CITY OF ALBUQUERQUE

January 13, 2016

RE: Durango at the Trails (File: C09D012), Unit 2
Grading and Drainage plan, Stamp Date 11-30-15 (Sheets 2 and 5)
Interim Grading and Drainage plan, Stamp Date 11-30-15

City Project No.	XXXXXX	Zone Map No.	C-09-Z	Sheet	2	Of	5
------------------	--------	--------------	--------	-------	---	----	---

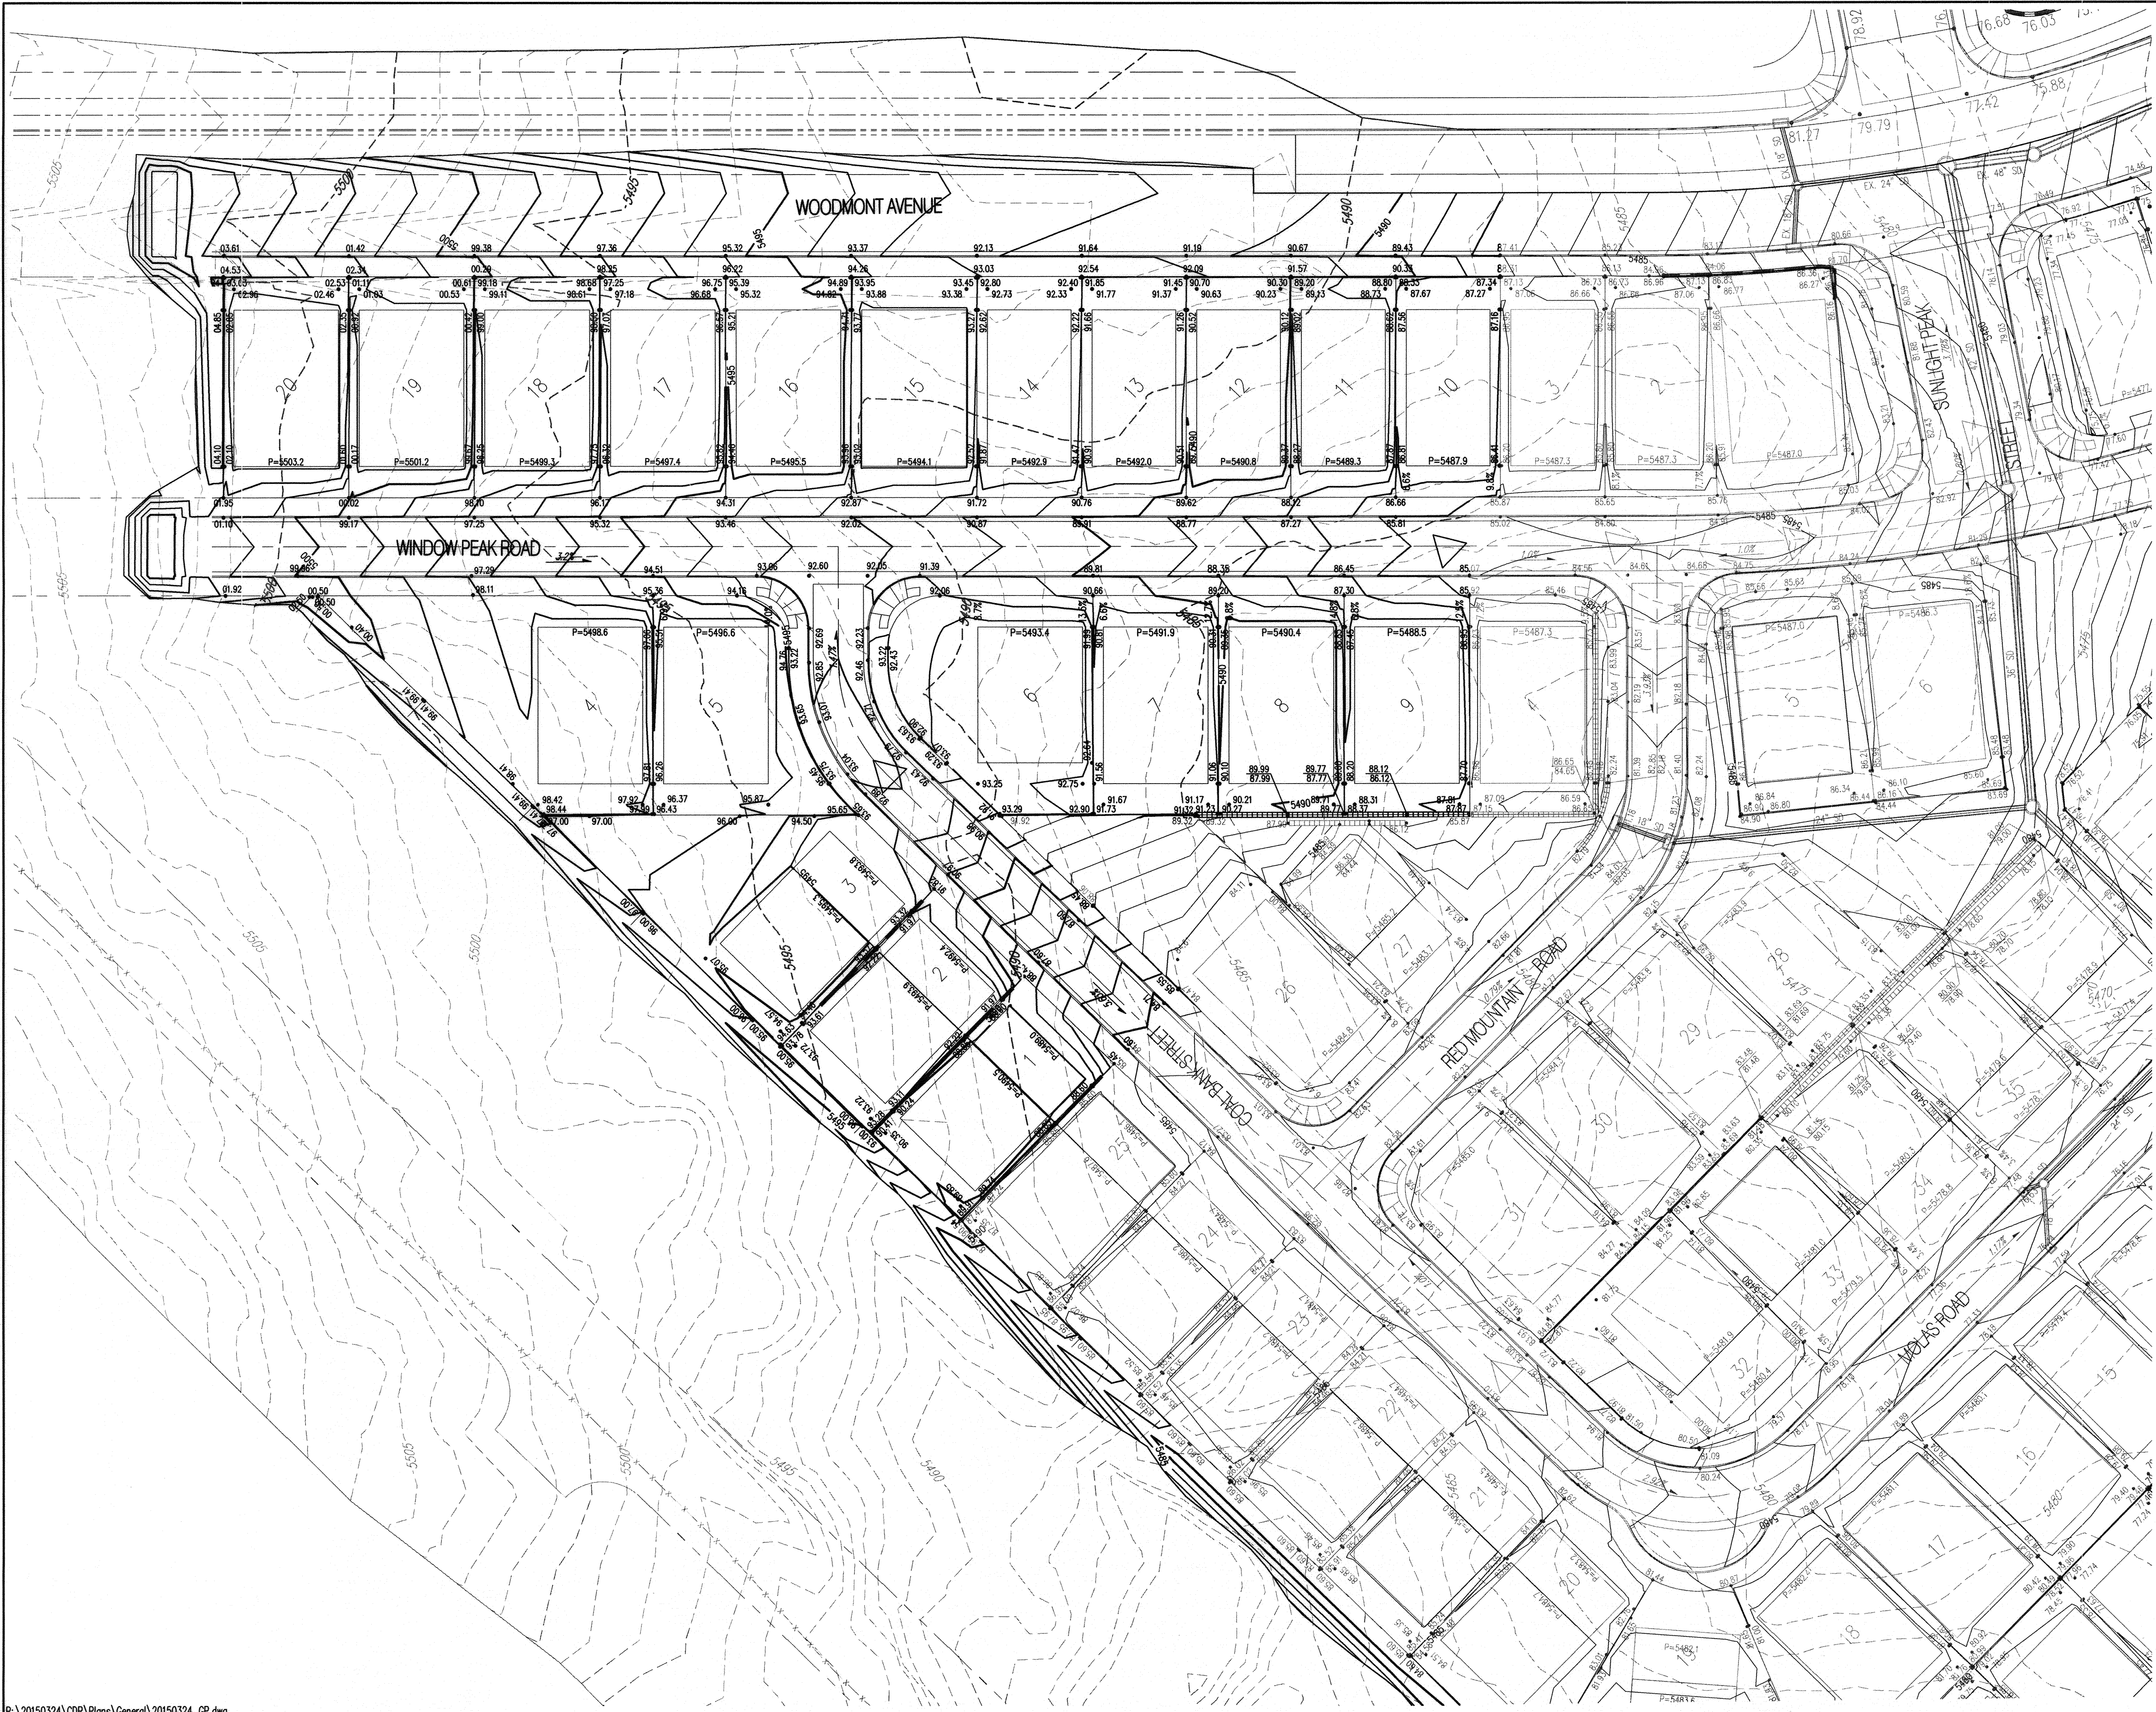
1. As a condition of Work Order acceptance, provide temporary drainage easements over interim ponds.
